Application Ref:	2025/0652			 Ribble Valley Borough Council www.ribblevalley.gov.uk
Date Inspected:	16/01/2026	Site Notice:	16/01/2026	
Officer:	EP			
DELEGATED ITEM FILE REPORT:				APPROVAL

Development Description:	Proposed extension to existing approved agricultural building.
Site Address/Location:	Hall Barns Farm Knowles Brow Hurst Green BB7 9PT.

PROPOSED ELEVATIONS
 (Sheet 1 of 2)

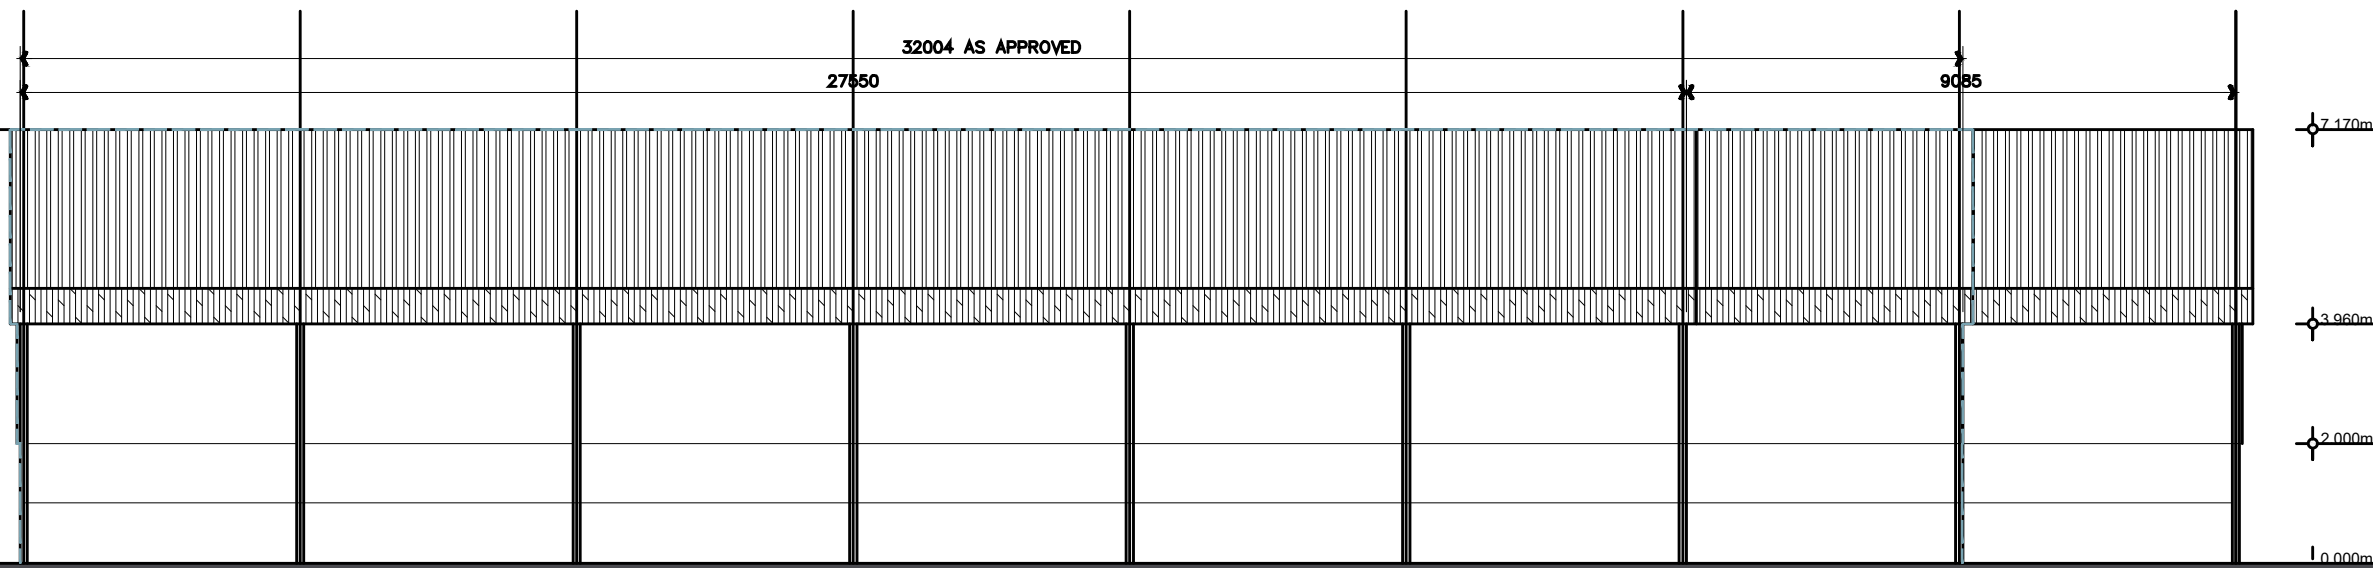
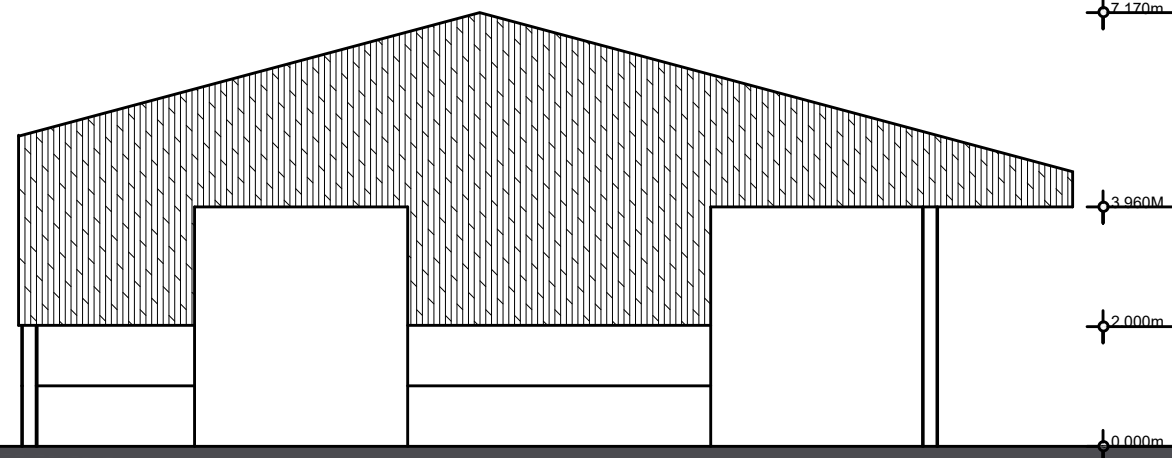
The development site is in close proximity to a United Utilities water main. Following consultation an amended scheme has been sought to allow a 5m clearance of the easement. Whilst United Utilises raised an initial objection, they have since removed this following submission of amended plans. Subject to the imposition of a condition relating to surface water drainage.
